Subject: RYDON FARM, TALATON 22/2439/AGR

Thank you for submitting the above planning application. This application is being validated by TerraQuest, on behalf of East Devon. Unfortunately the application is invalid at present for the following reason(s):

Rydon House, Talaton, Exeter, EX5 2RP

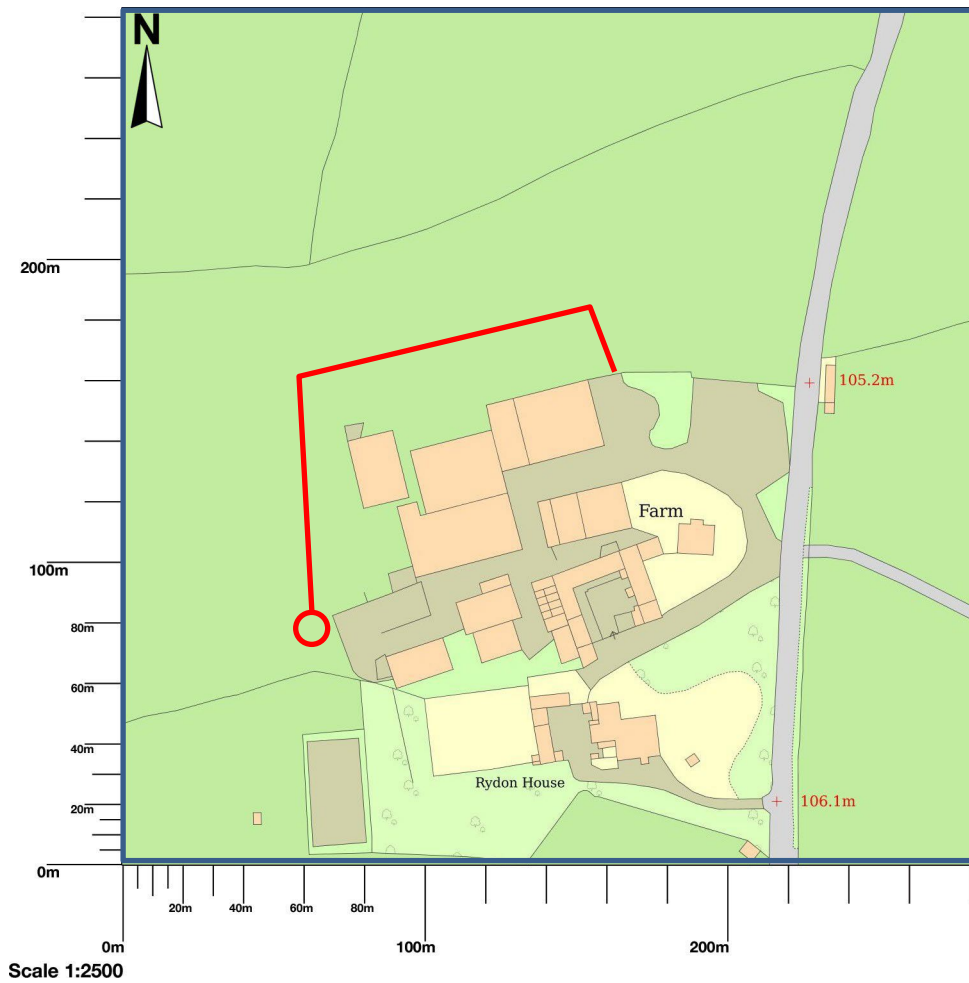
1. Location Plan: You are required to include the access all the way to the main road leading to the proposed site within the red outline.
2. Location Plan: the red outline is required to be a double line which fuses with the annotated structure on each plan

1. Location Plan: You are required to include the access all the way to the main road leading to the proposed site within the red outline.
The proposed track is accessed from the existing farm track which leads from the main road to the existing field gate (as annotated). The proposed track is not reliant on access from the main road.
2. Location Plan: the red outline is required to be a double line which fuses with the annotated structure on each plan
The proposal is for a farm track 2.4m wide (as per the supporting information) which would not read as a double line on the map as scaled. A previous application was submitted and validated with similar information.
